REQUEST

Current Zoning: R-22MF(CD) and C-2 for the City of Concord portion.
Proposed Zoning: R-22MF(CD) SPA and R-22MF(CD) with five year vested rights.

Approximately 48.21 acres located west of Quay Road, south of Mallard Creek Road, and northeast of Ridge Road.

The petition proposes a unified development plan with common uniform zoning and development regulations for the development of a residential multi-family community on the entire 48.21 acre site which includes both the 36.67 acre Charlotte portion and the 11.54 acre Concord portion. The petition proposes up to 700 multi-family dwelling units.

EXISTING ZONING: R-22MF(CD) FOR CLT PORTION PER PET. #2021-020 AND C-2 FOR CONCORD PORTION

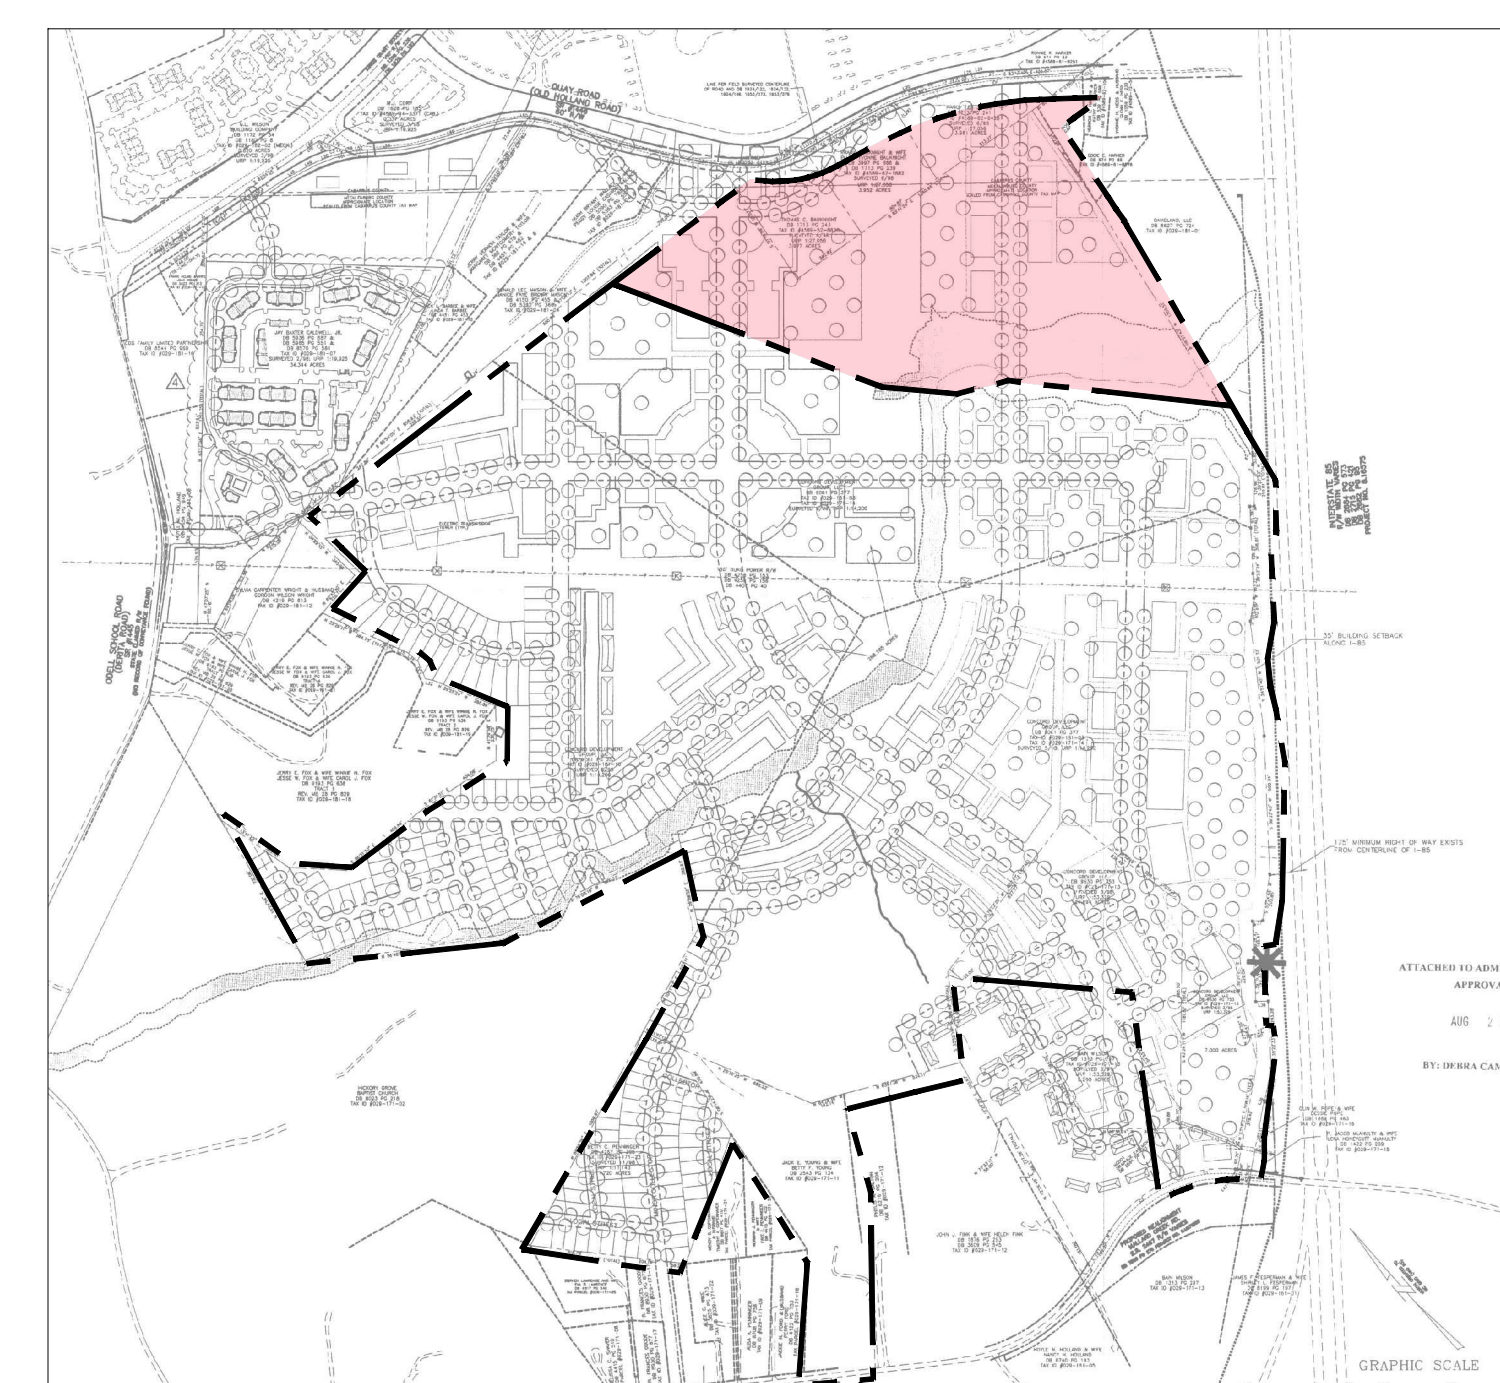
1. ~~Label and call out 8-foot planting strip and 8-foot sidewalk on roads on site plan.~~ Addressed
2. ~~Based on latest conversation with Land Development Subdivision, please label Road B as publicly maintained within Mecklenburg county on site plan and alter conditional notes in sections 3, 4, and 5 to reflect changes.~~ Addressed
3. ~~Revise site plan and conditional notes(s) to commit to coordinating with CATS to provide a public connection to the nearest CATS bus stop to the North of the site.~~ Addressed

4. ~~Minimum open space for R-22MF is 40%. Update plan.~~ Addressed
5. ~~In section 1e, the number of principle buildings (24 or 27) don't match.~~ Addressed
6. ~~Setbacks will apply to all internal required streets.~~ Addressed
7. ~~Make Road B public.~~ Addressed
